From: Amanda Scholes on behalf of Planning.Responses
Sent: 28 August 2018 08:33
To: Planning Scanning
Subject: FW: Planning Consultation on: AL/86/18/PL

Engineers Comments Regarding Surface Water Drainage
Please apply ENGD2B.

APPLICATION **AL/86/18/PL**

Description of Works: Application to vary condition No.4 of previously approved planning application AL/50/13 to increase the number of mobile homes for permanent residential units from 2 to 3No. units.

B	show unit 3 plus drainage details.	8/18
A	Add drainage and delete storage of 2 caravans	5/13
Mr. J. Horton		
The Old Barn, Arundel Road, Fontwell. BN18 0SX		Richard Stubbs MRTPI
		TEL: 01243 825944
Mobile Home (3rd Unit)		06/12/B
1:2500	1:500	August 2018
		1 of 1

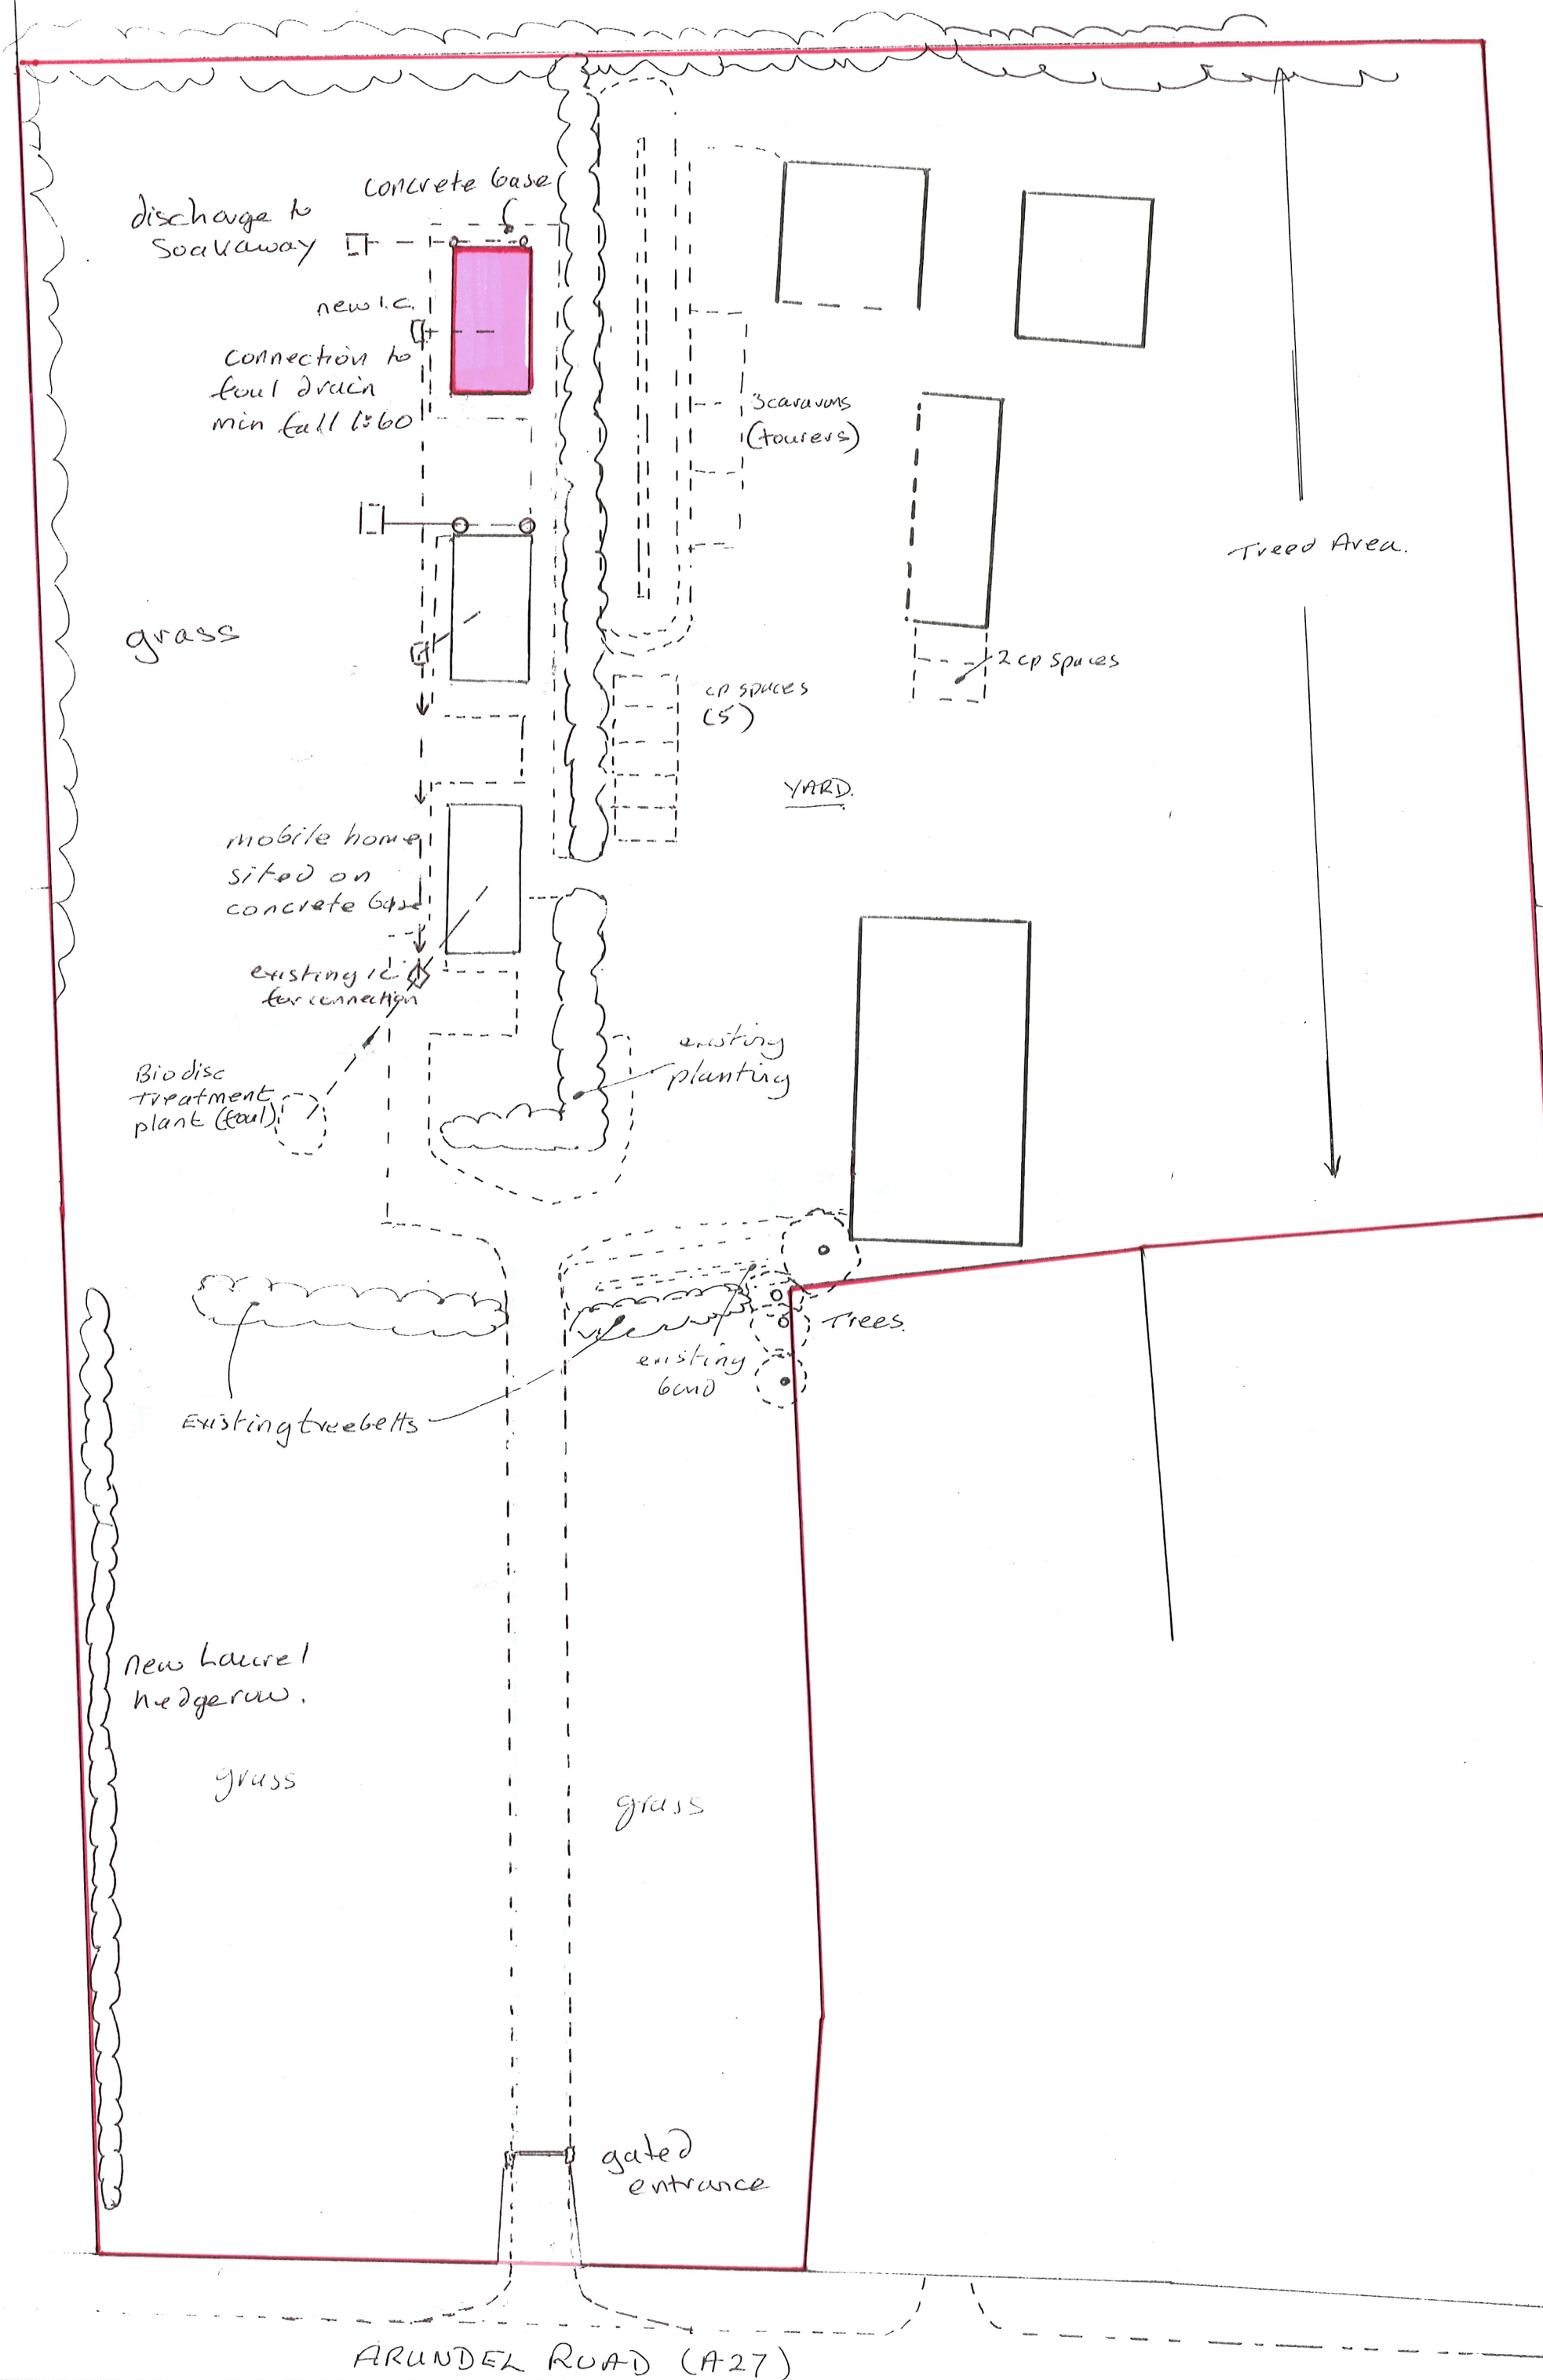
Soakaways must be investigated for surface water disposal.

Infiltration rates for soakage structures are to be based on percolation tests undertaken in the winter period and at the location and depth of the proposed structures. The percolation tests must be carried out in accordance with BRE 365, CIRIA R156 or a similar approved method and cater for the 1 in 10 year storm between the invert of the entry pipe to the soakaway, and the base of the structure. It must also have provision to ensure that there is capacity in the system to contain below ground level the 1 in 100 year event plus 40% on stored volumes, as an allowance for climate change. Adequate freeboard must be provided between the base of the soakaway structure and the highest recorded annual groundwater level identified in that location.

Any SuDS or soakaway design must include adequate groundwater monitoring data to determine the highest winter groundwater table in support of the design. The applicant is advised to discuss the extent of groundwater monitoring with the Council's Engineers. Supplementary guidance notes are also enclosed for information.

It should also be noted that the site is within a groundwater source protection zone, therefore sufficient treatment of water to the ground will have to be demonstrated.
